**Date:** 04/18/2025

**Re:** **Notched Roof Trusses**  
Location: Lot 8 Honeycutt Hills (Angier, NC)  
JDS Project No.: RDU2504070  
Date of Inspection: 04/17/2025

ROOF

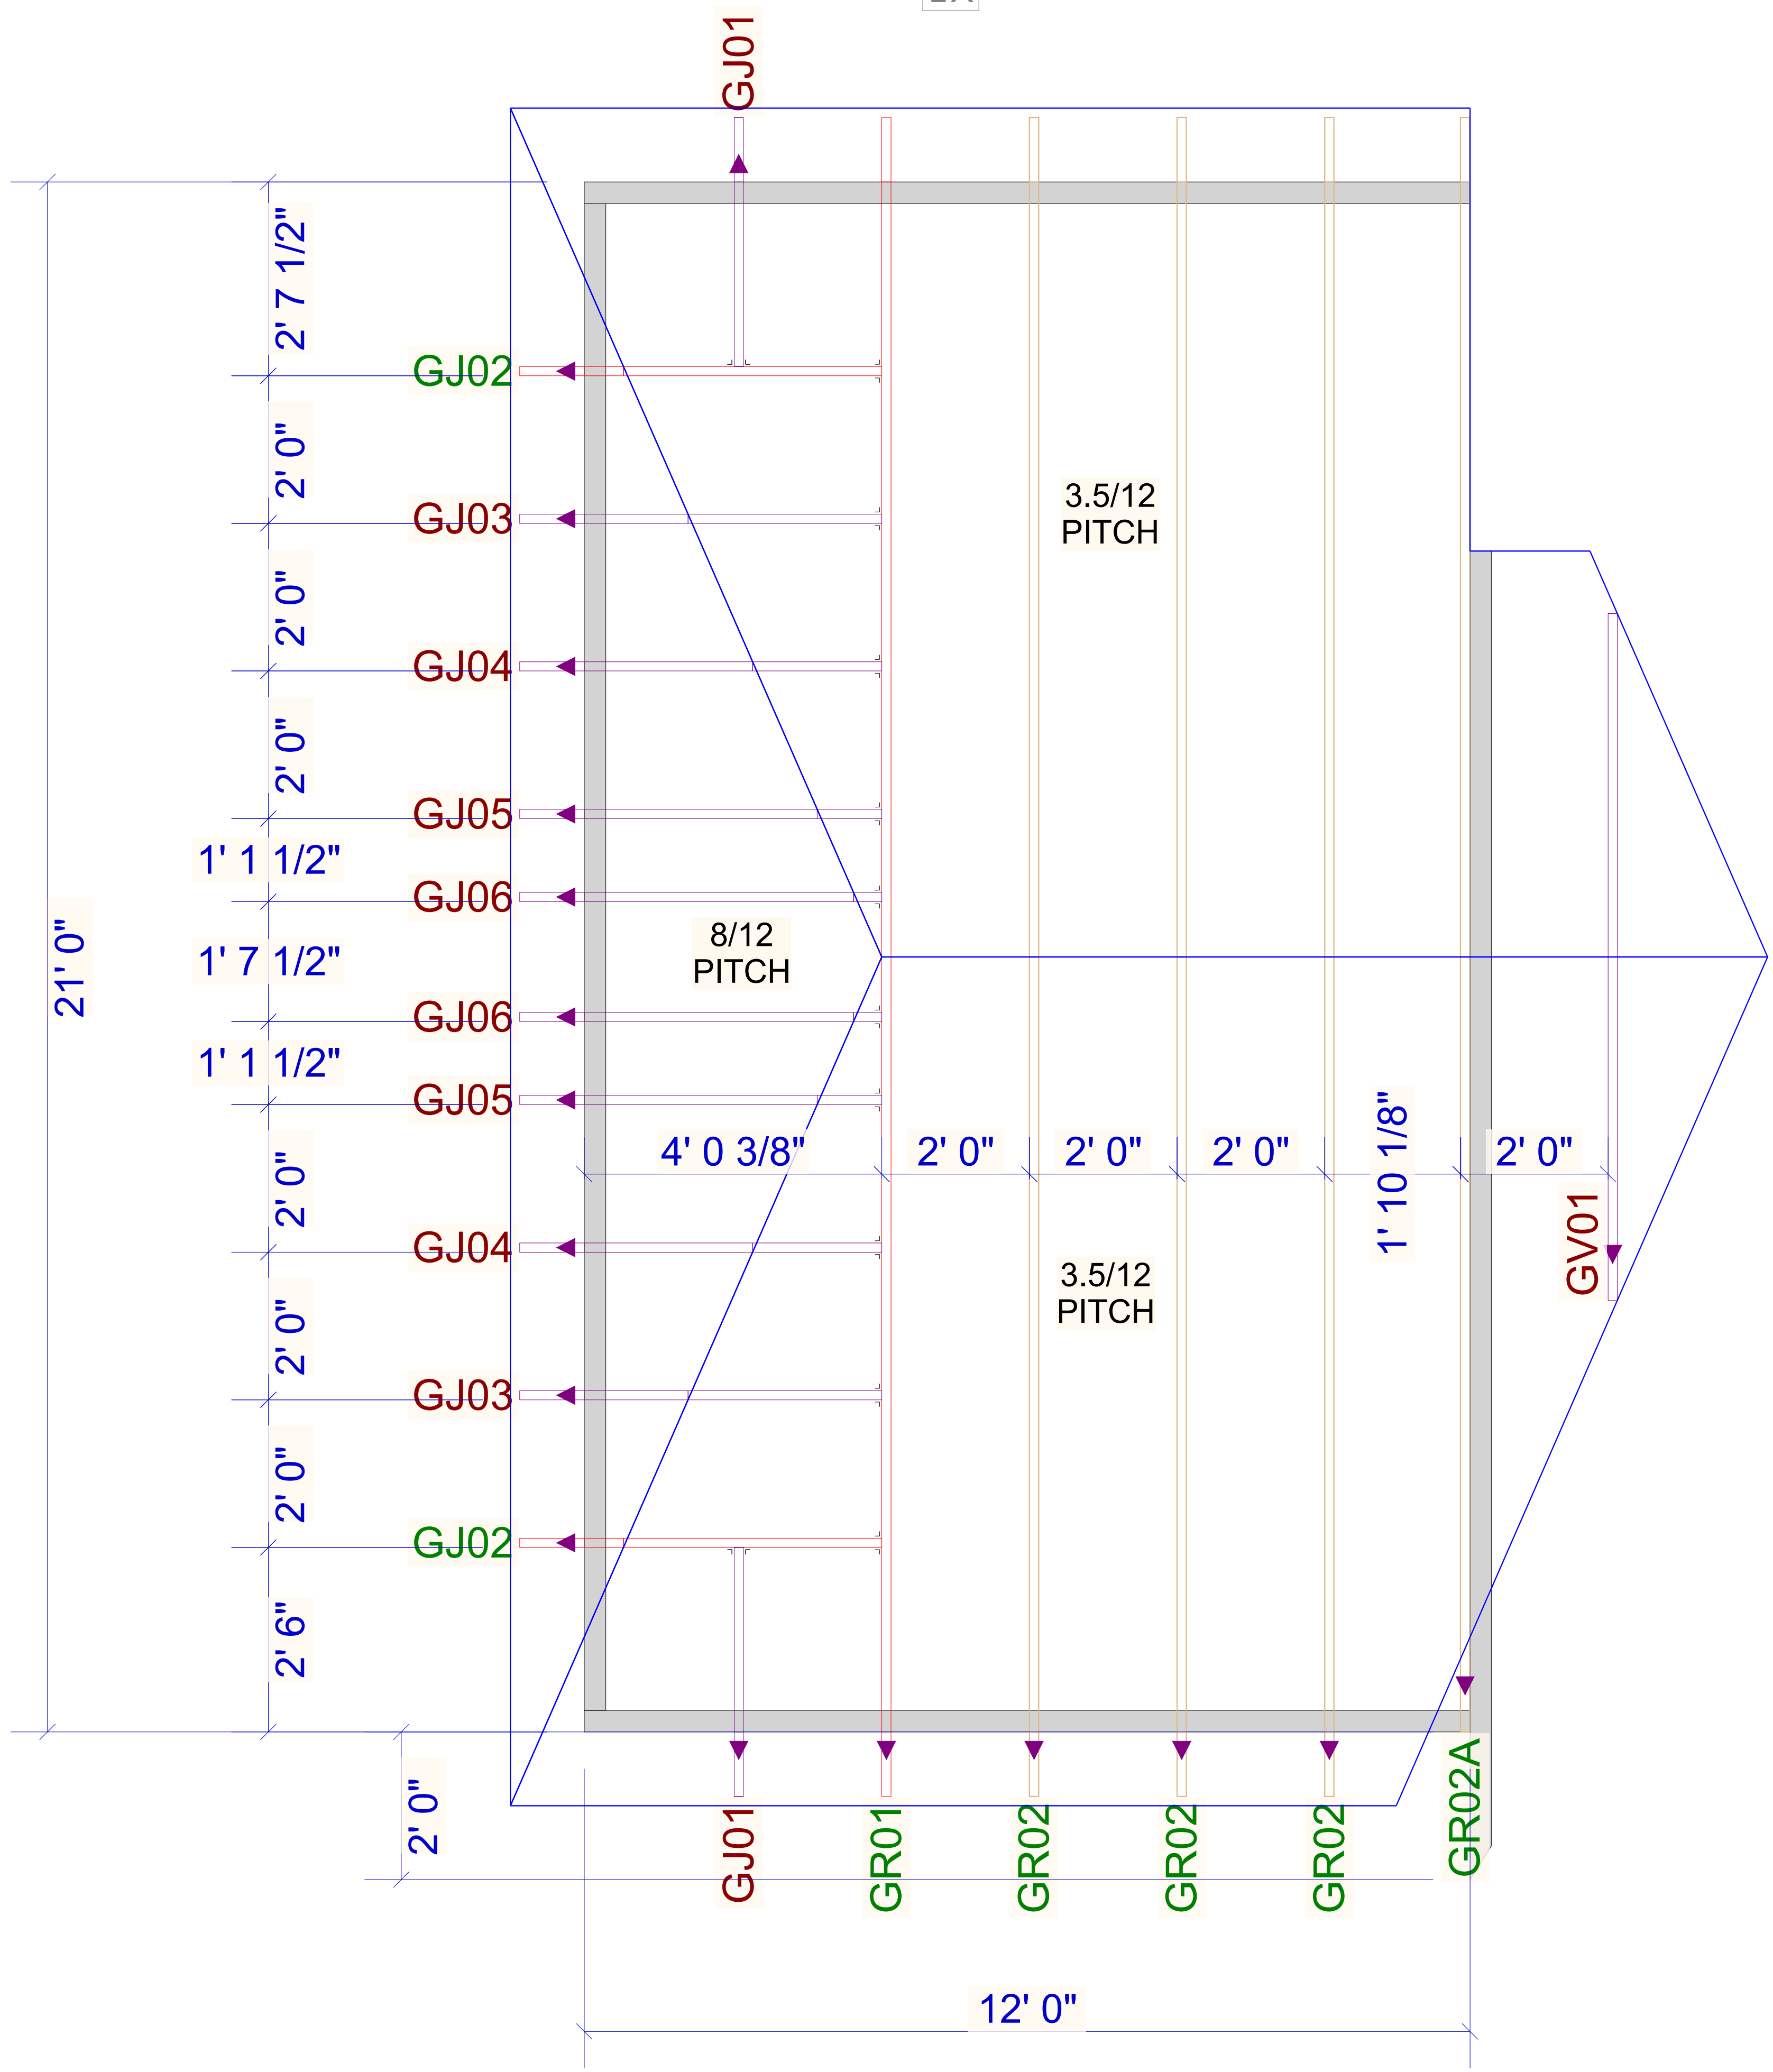
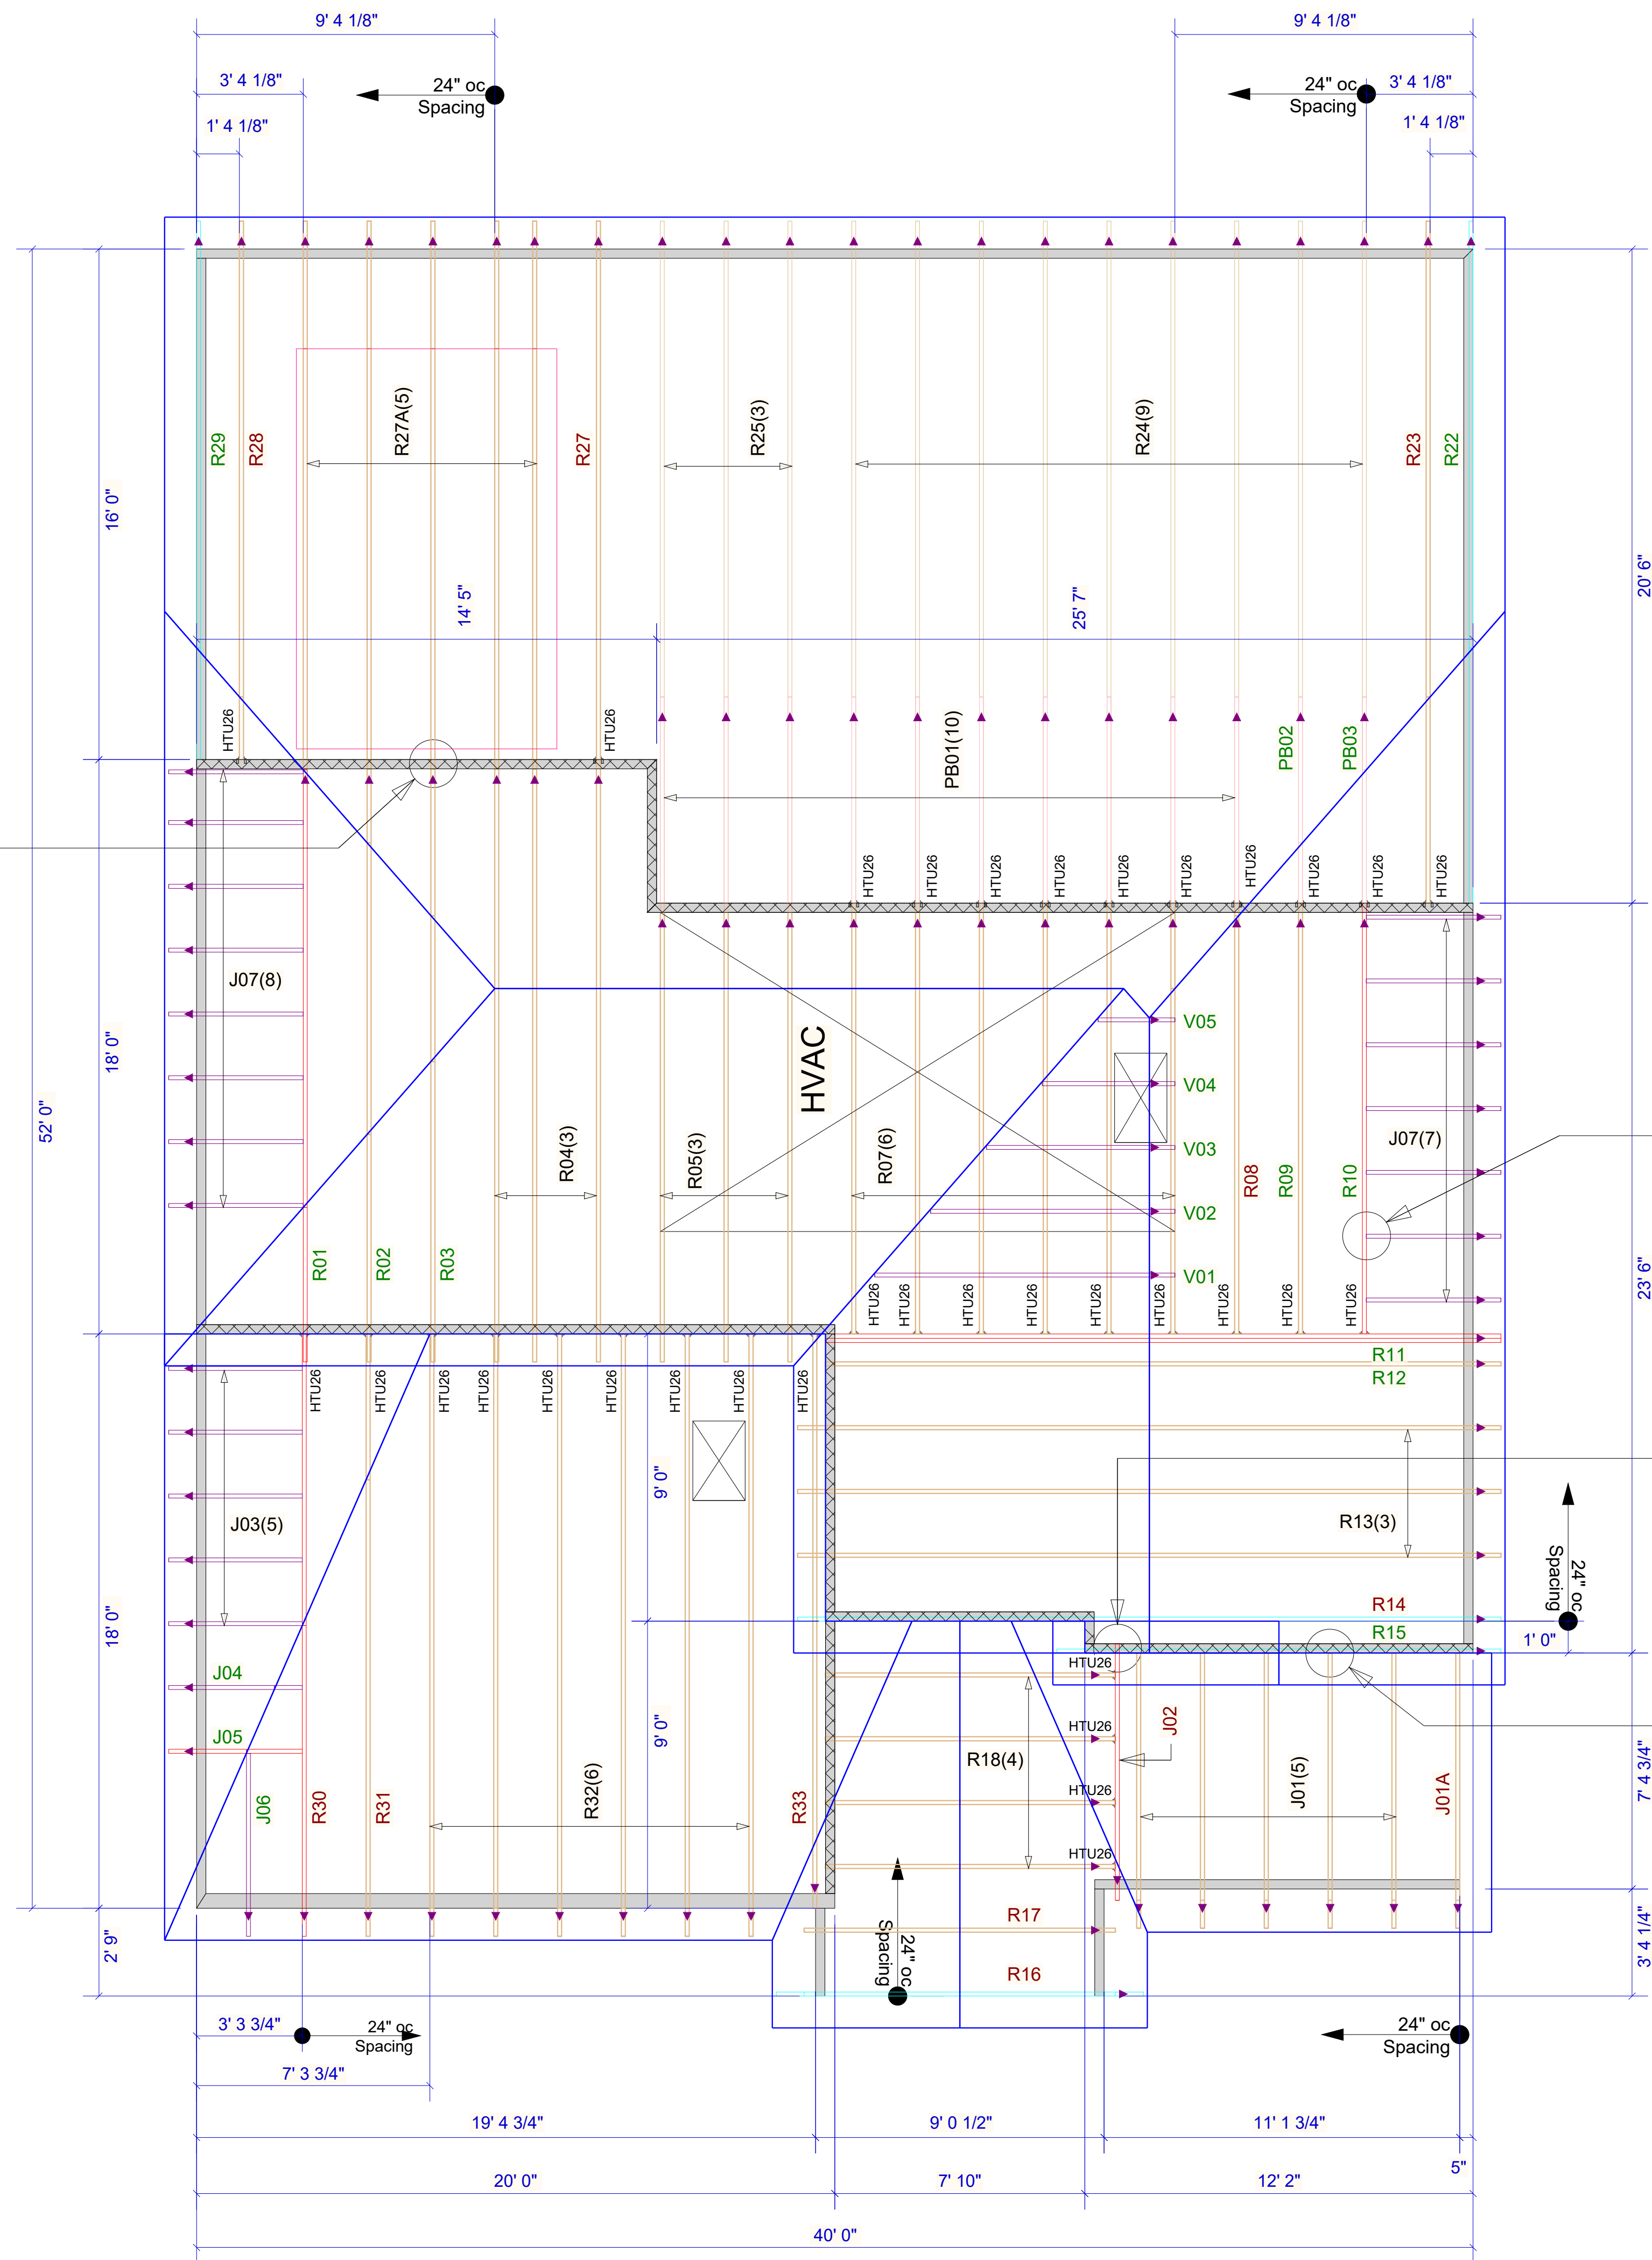
At the attic access door frame at the right rear bedroom access to the rear attic, the installation has notched the vertical webs of the (2) adjacent trusses by as much as 1-1/2" at the top and bottom of the door frame.

Based on our onsite observations and review, at each of the (2) damaged web members install an 8' long 2x4 scab to each face of the web, beginning at the bottom of the bottom chord and attached with (2) rows of 10d nails at 4" o.c.
